CITY OF ALBUQUERQUE

March 14, 2013

Re: Silver Moon Apartments
Grading and Drainage Plan
Engineer's Stamp dated 3-8-13 (K13/D072)

DRAWN BY
REVIEWED BY
DATE 5.8.2013
PROJECT NO. 17-1013-01
DRAWING NAME
**SILVER MOON LODGE
GRADING AND
DRAINAGE PLAN**

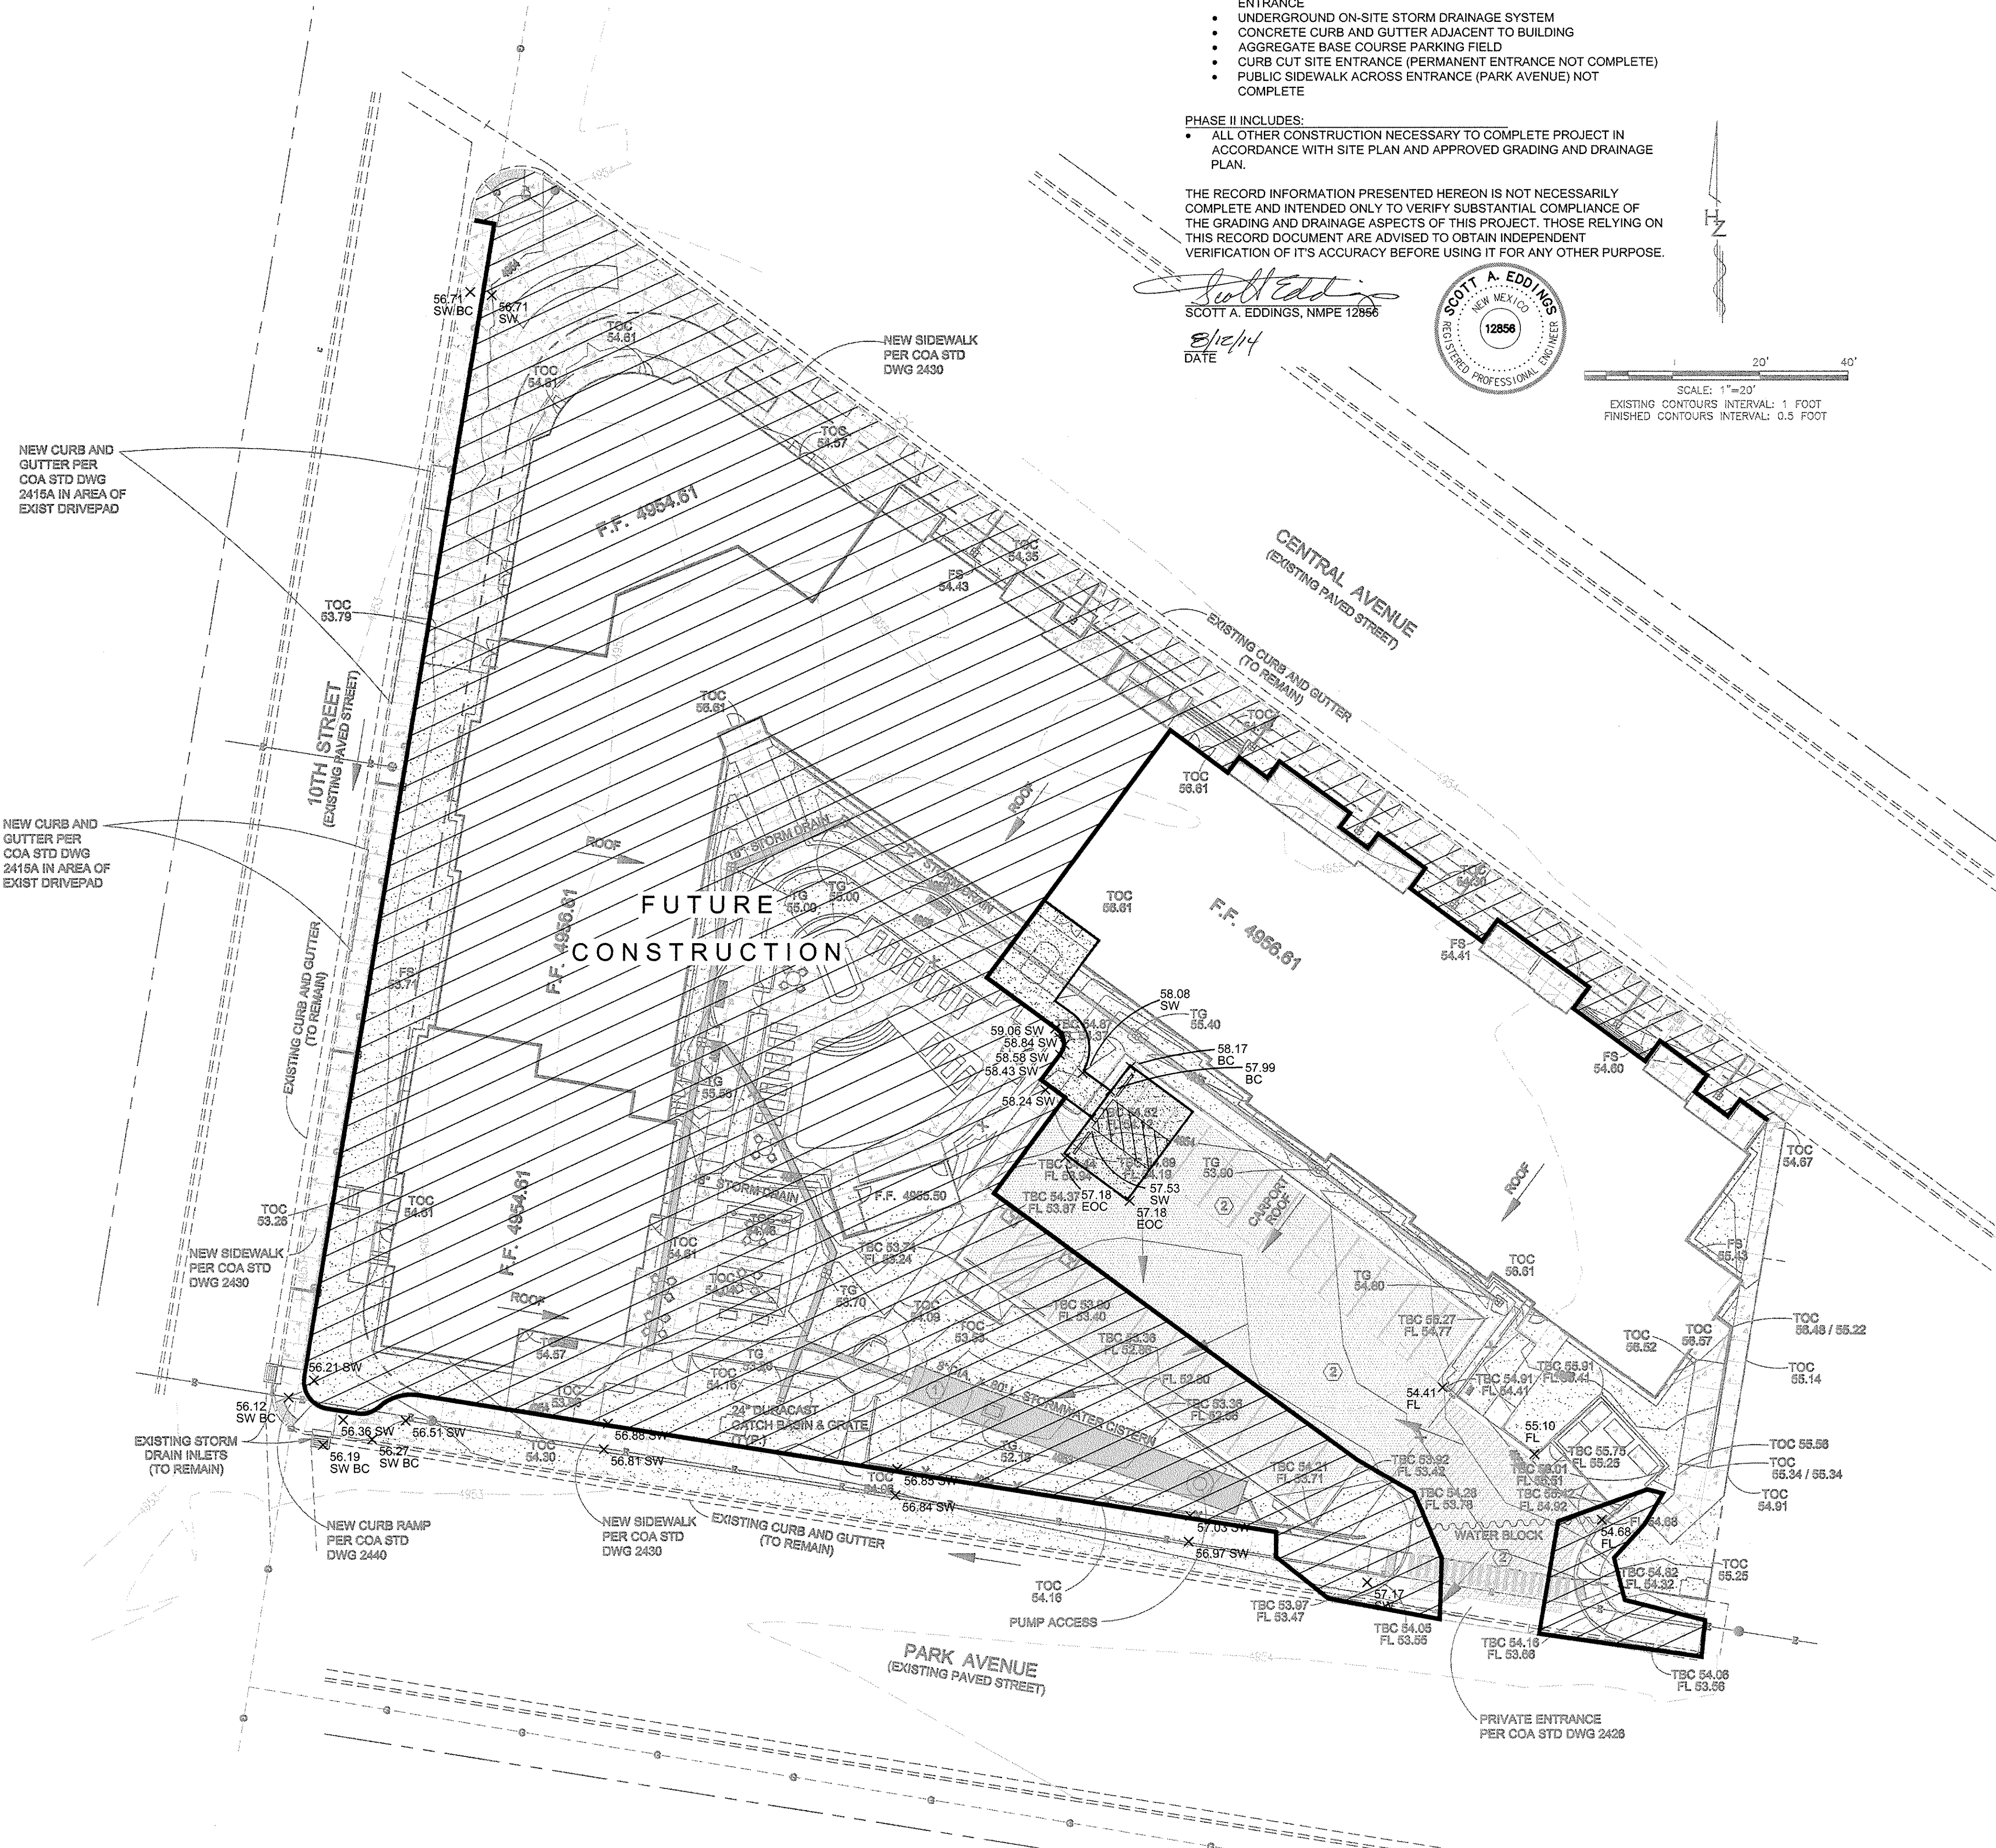
- Use Section 22.2 of the Development Process Manual, City of Albuquerque, for the input information into the AHYMO program.
- Depress all landscape areas to retain all moisture which falls on them.
- Provide volume calculations for the cistern, a detail of the cistern, as well as the pump specifications. Is this pump automatic or manual?
- How are the flows in the parking lot reaching the cistern?
- It would be preferable if the water leaving the cistern went through a rock swale before entering the public street.
- Provide a water block at the entry/exit to the parking lot.
- Please be advised that before any permit can be issued an Erosion and Sediment Control Plan (ESC), prepared by a registered professional engineer under the laws of the state of New Mexico, must be prepared, submitted and approved by the Hydrology Department.
